From: Brian Wilson [brian@wnag84.isnet.co.uk]
Sent: 23 June 2015 17:49
To: ryan@bbr-architects.co.uk
Cc: Mark Peacock
Subject: Planning application no. S6/2015/1034/MA

Application No.	Description and Location	Applicant/Agent
S6/2015/1034/MA	Change of use from existing offices (B1) to six residential dwellings (C3), extension and conversion of existing loft space to one dwelling and erection of new block in existing car park to provide three dwellings 31 Salisbury Square Hatfield AL9 5JD	Mr R Albone BBR Architects Merchant House 22 Bancroft Hitchin SG5 1JW

WELWYN HATFIELD ACCESS GROUP'S RESPONSE TO PLANNING APPLICATION S6/2015/1034/MA

CONTRACT
**Refurbishment & Conversion of
 31 Salisbury Square
 Hatfield
 AL9 5JD**
 DRAWING TITLE
Proposed Floor & Roof Plans

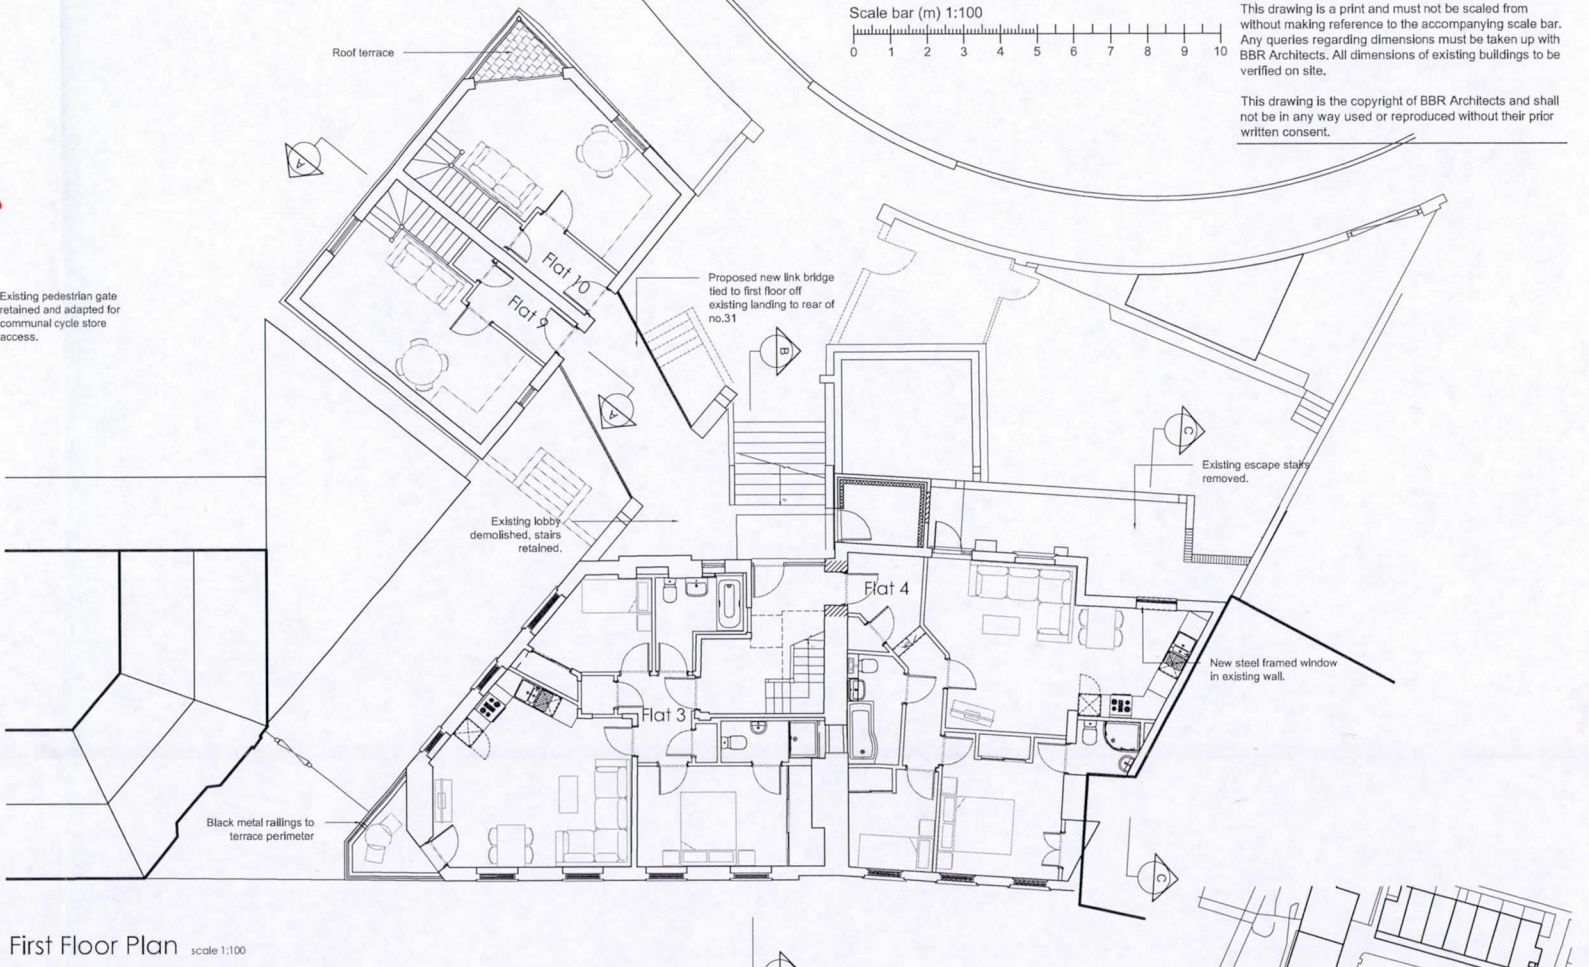
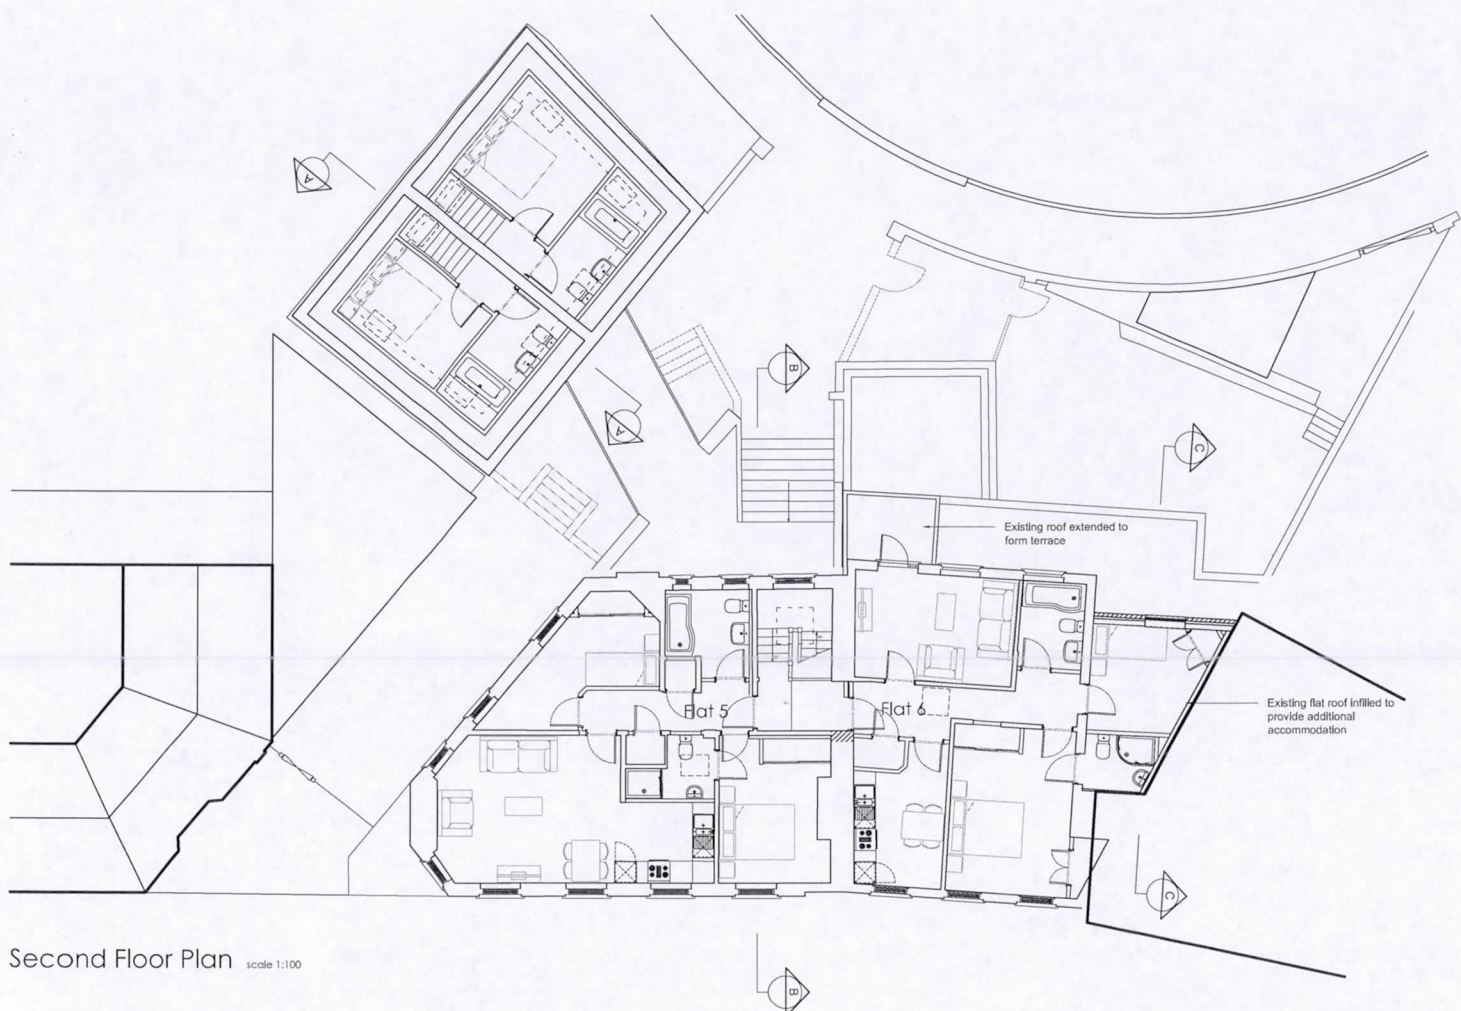
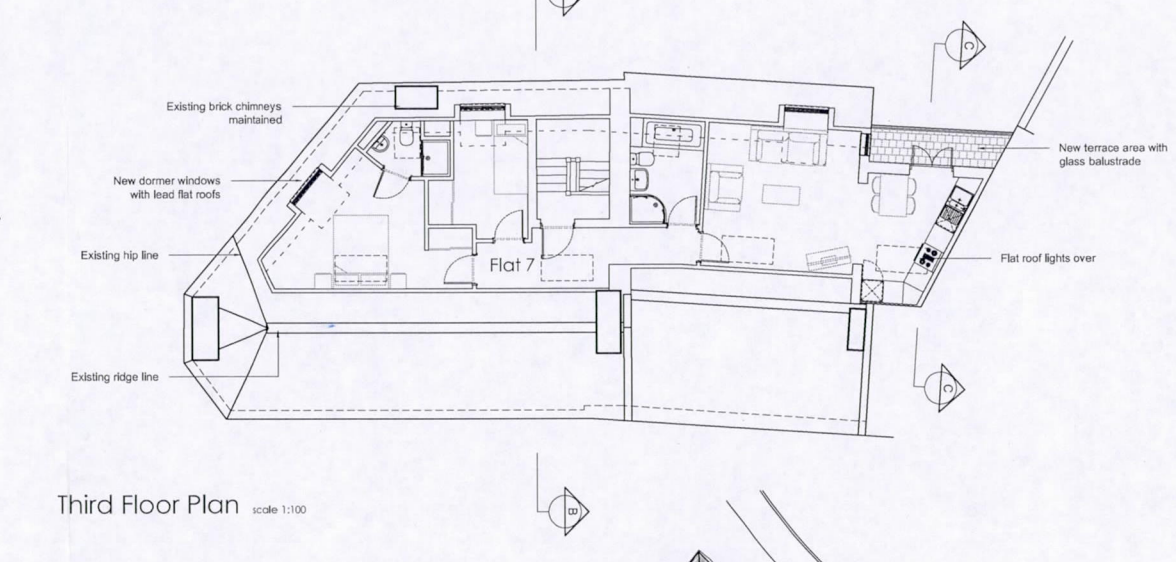
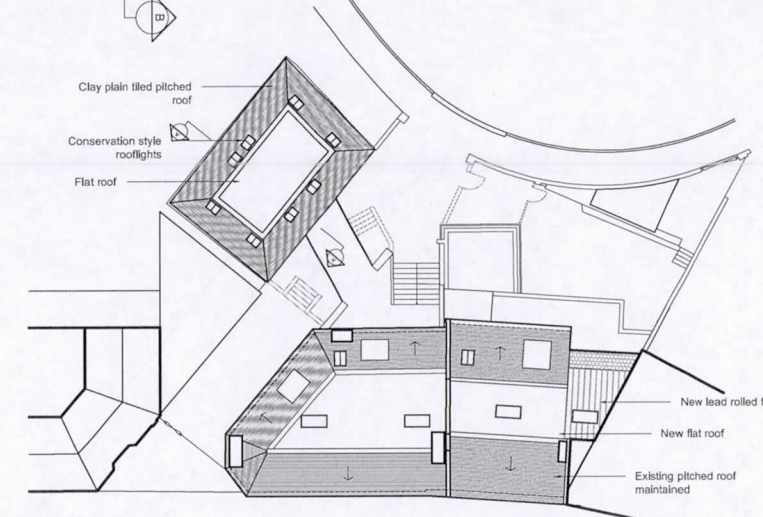
Heading	Section	Page	WHAG Observations	WHAG Comments
DESIGN AND ACCESS STATEMENT	THE PROPOSALS	4	<p>The application proposes to convert the existing building into 6 no. 2-bedroom apartments; construct a 2¹/₂ storey building within the car park to provide 1 no. 2-bedroom and 2 no. 1-bedroom apartments linked to the existing property by a small bridge, and to create a new 2-bedroom apartment on and within the roof space of the existing building.</p> <p>The application also includes minor elevation changes to the rear to facilitate the change of use. Changes are also proposed to the existing levels along the pedestrian link.</p>	<p>We regret to note the absence of any reference to the physical access provisions in the proposed new apartments in this application. We appreciate it is an existing old building but firmly believe appropriate provisions for physical access for all especially in the new build parts should be provided:</p> <p>We regret we are unable to determine what provisions, if any, are proposed as we cannot accurately identify details from the drawings provided on the WHBC website. We refer specifically to drawings, number P12 – Proposed floor and roof plans, and number P13 – Proposed elevations, sections and sketch visual.</p> <p>We believe there are various sets of steps in and around the proposed development which severely impacts of free movement by those with physical impairments including those with pushchairs.</p> <p>The same drawing indicates the provision of two new sets of access steps providing access to the proposed principal ground floor entrance to Flat 1. Is there any possibility of providing a ramp at one of these to avail access for wheelchairs?</p> <p>We have been unable to identify the location/provision of any external stairs from the apartments on the upper floors. Could you kindly advise if they are already available and, if not, the location of a refuge point for the upper floor apartments?</p> <p>We would appreciate your comments.</p>
